Date: April 24, 2018

From: Charles K. Cothorn, P.E.

Subject: Springs at Waterview

This memorandum has been prepared to provide response and clarification to the GMS letter dated February 22, 2018. The comment is listed followed by the response. Please find attached 3 sets of the revised plans for the above referenced project for your review along with a copy of the plat. One of the sets and a copy of the plat has been provided to GMS, Inc. for their review.

PDF-17 - STORM G & H PROFILES.PDF

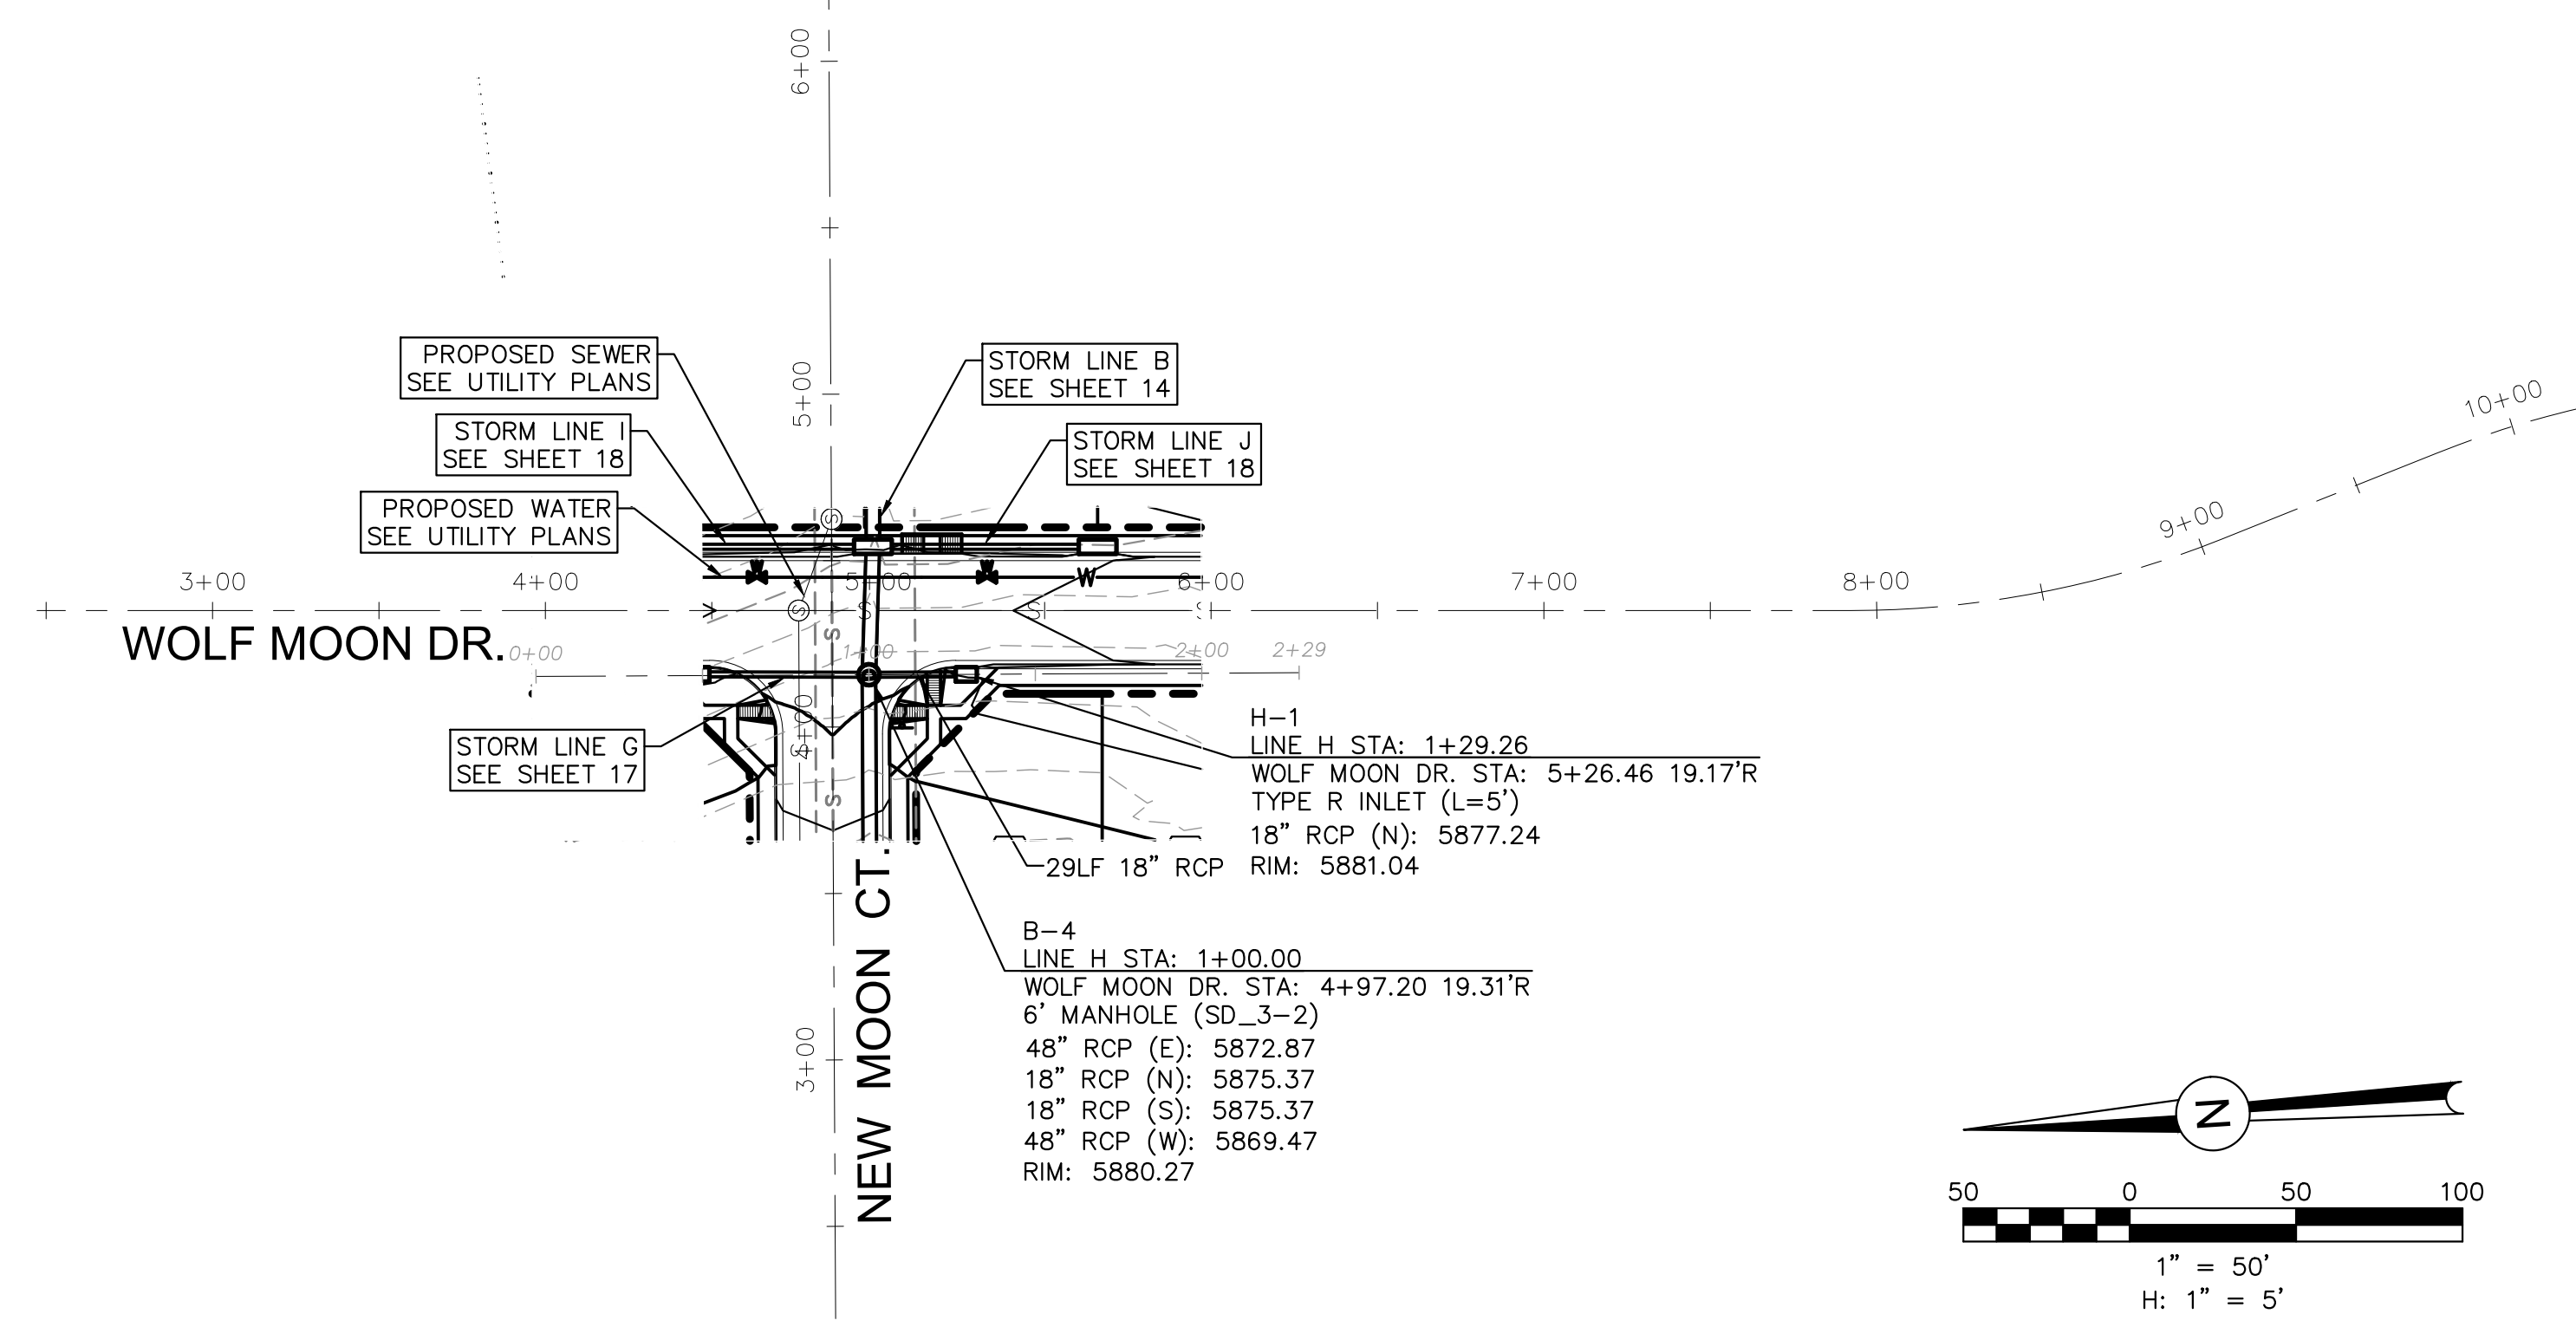
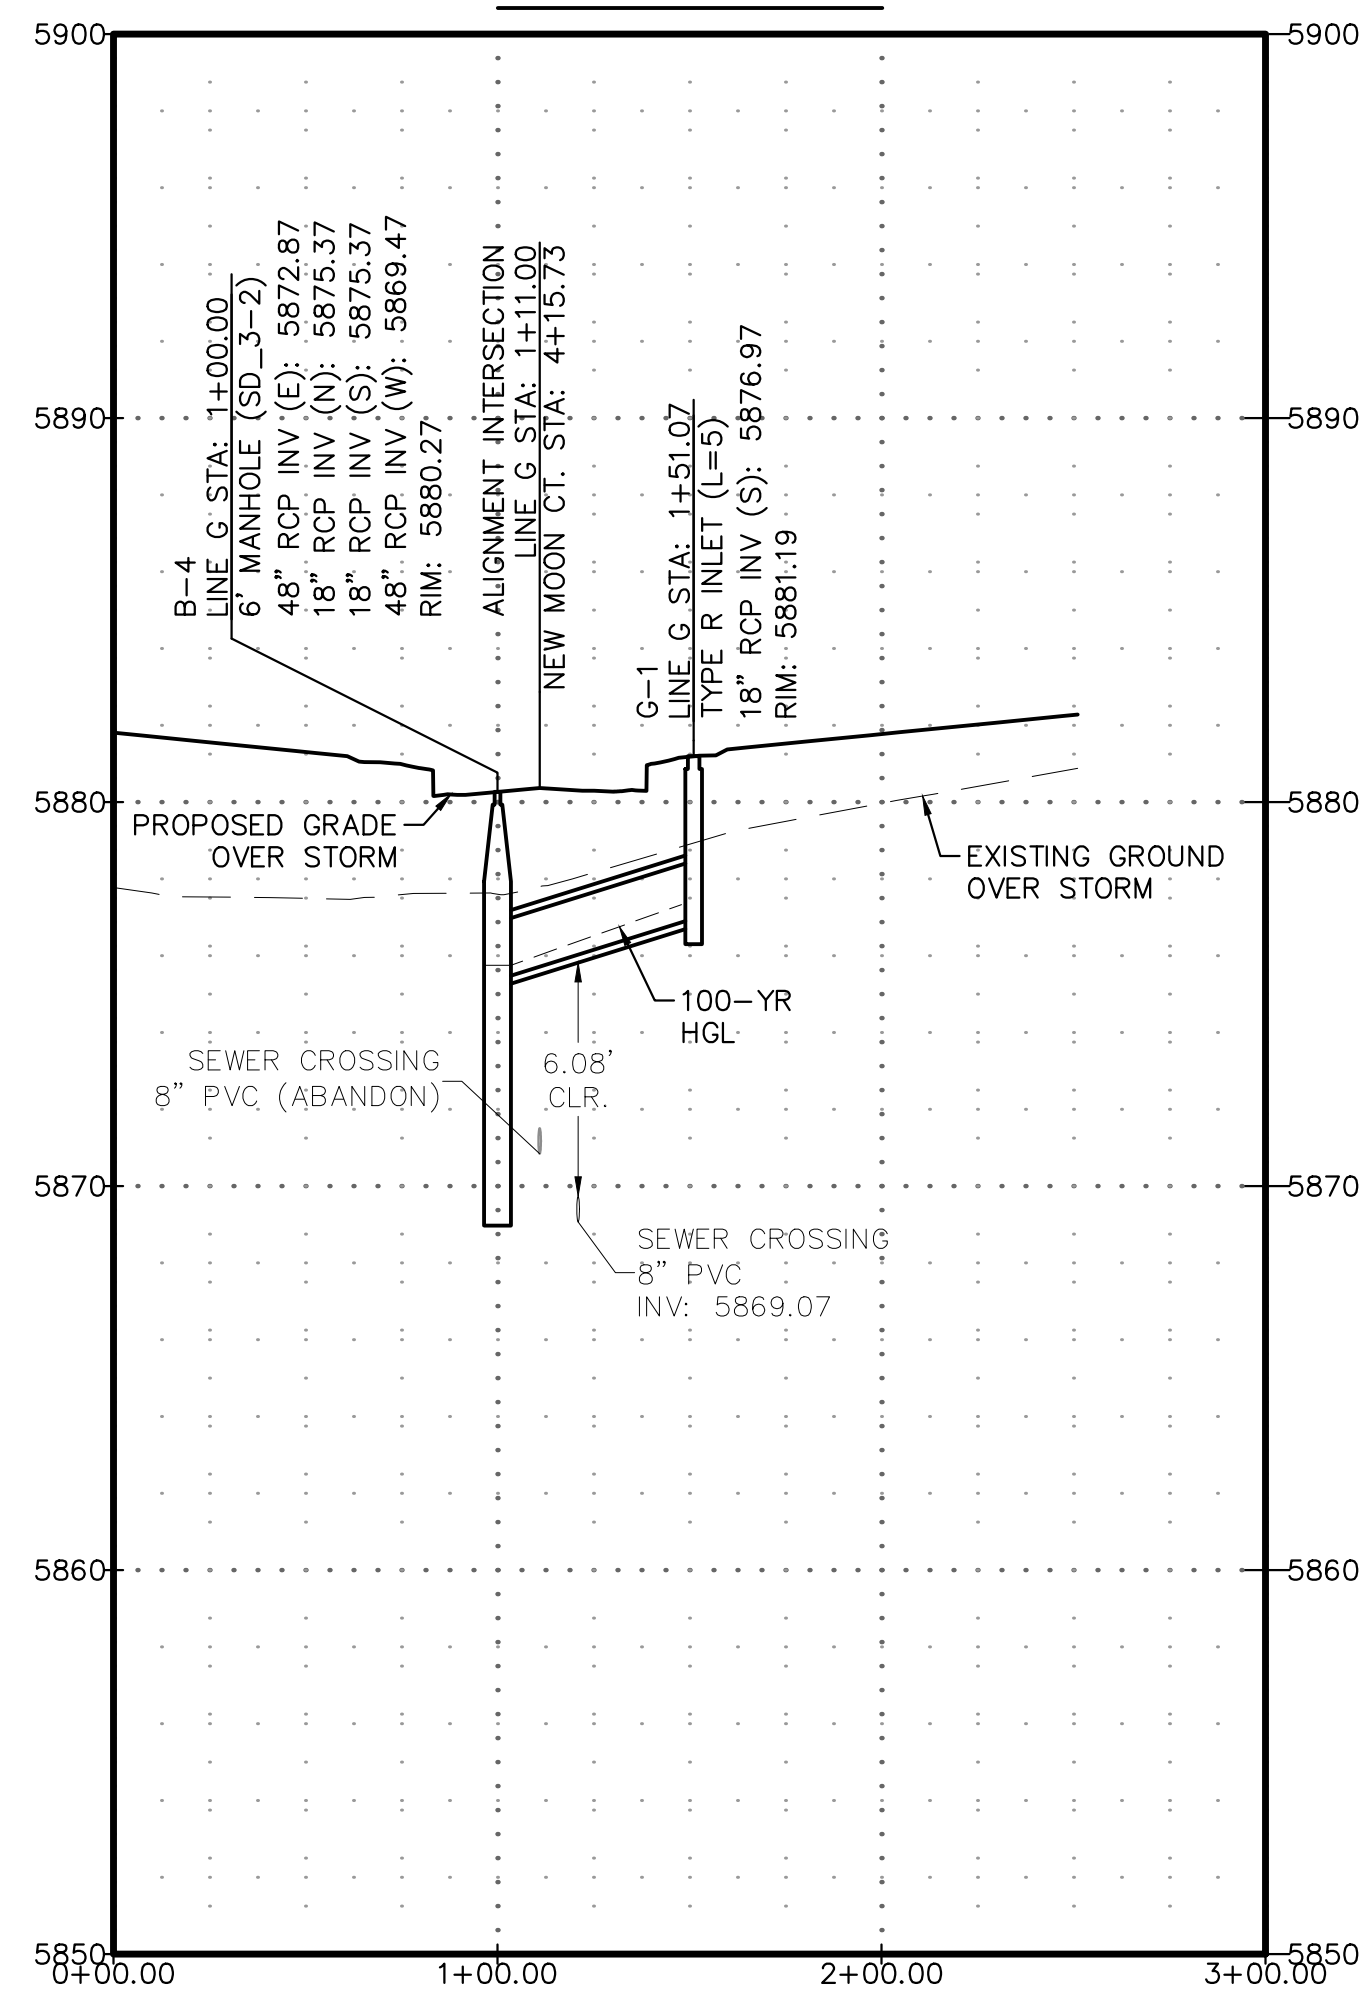
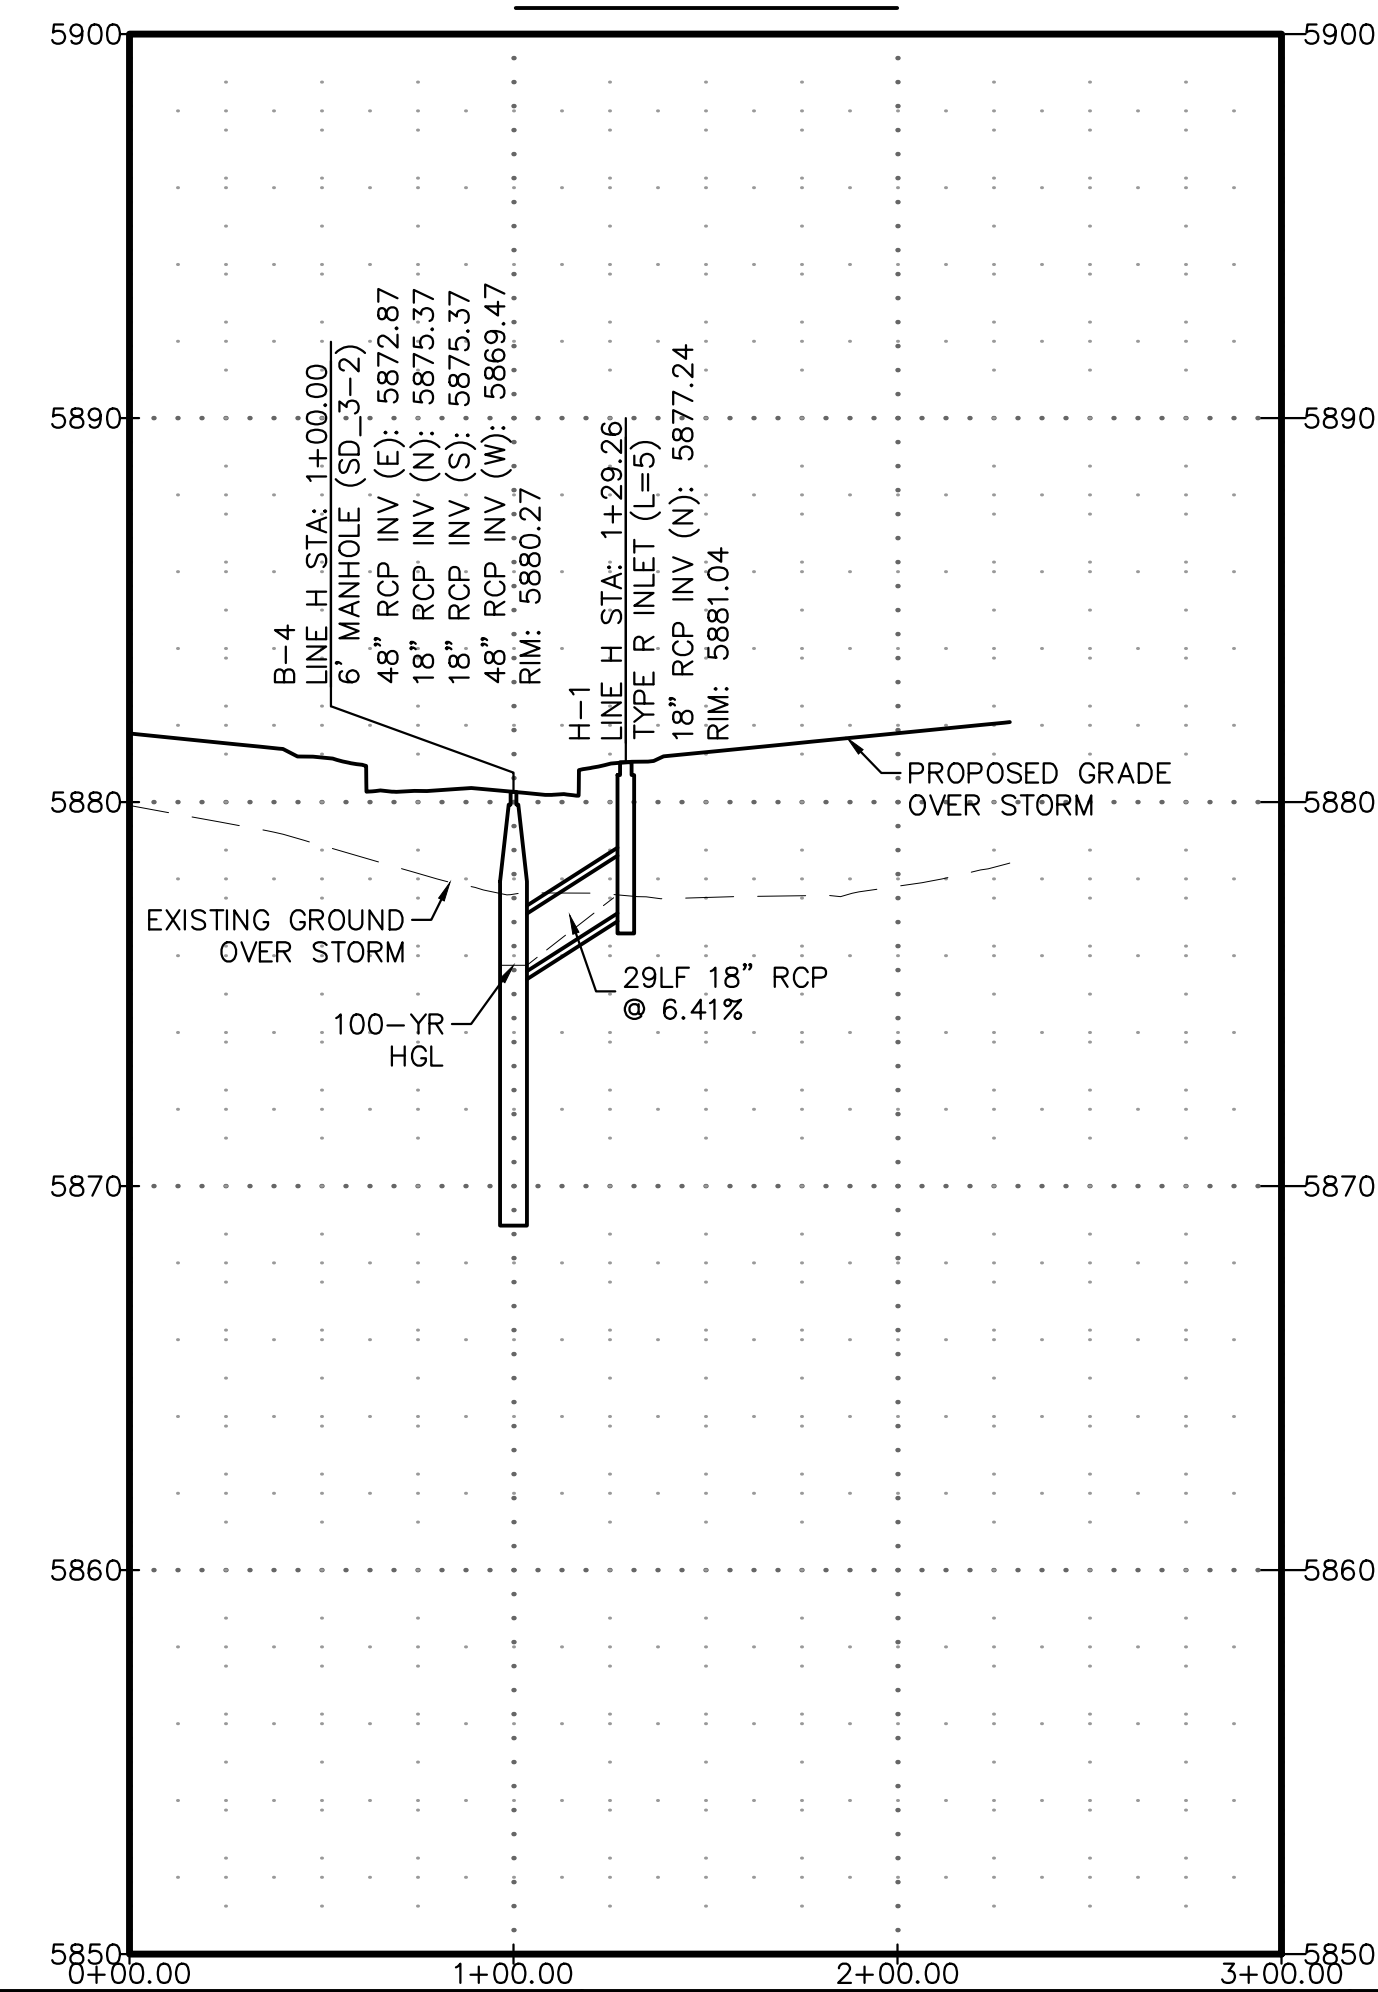
1. In order to accommodate efficient future water main maintenance by the District, please eliminate water main lowering underneath the proposed 18" storm Line G. Provide an 18' long water main casing pipe and maintain straight water main grade under the storm sewer. Provide a minimum of 6" clear separation between the storm sewer and casing pipe. The storm sewer shall be placed on reinforced concrete bridging blocks per the District's Standard Details.

2. In order to comply with the District's water service depth requirements and vertical separation requirements from sewers and other non-potable pipelines, please provide and indicate the use of water service sleeves where the water services will cross the Storm Lines G and H. Provide complete construction details.

DSE Response: There is no longer a storm crossing here.

DSE Response: Water service line callouts added to have service sleeves to be installed on Lots 9-10, 24-26, 49-50, and 71-73. Standard detail for sleeved crossings added to Sheet 5 of 11, titled Master Utility Plan.
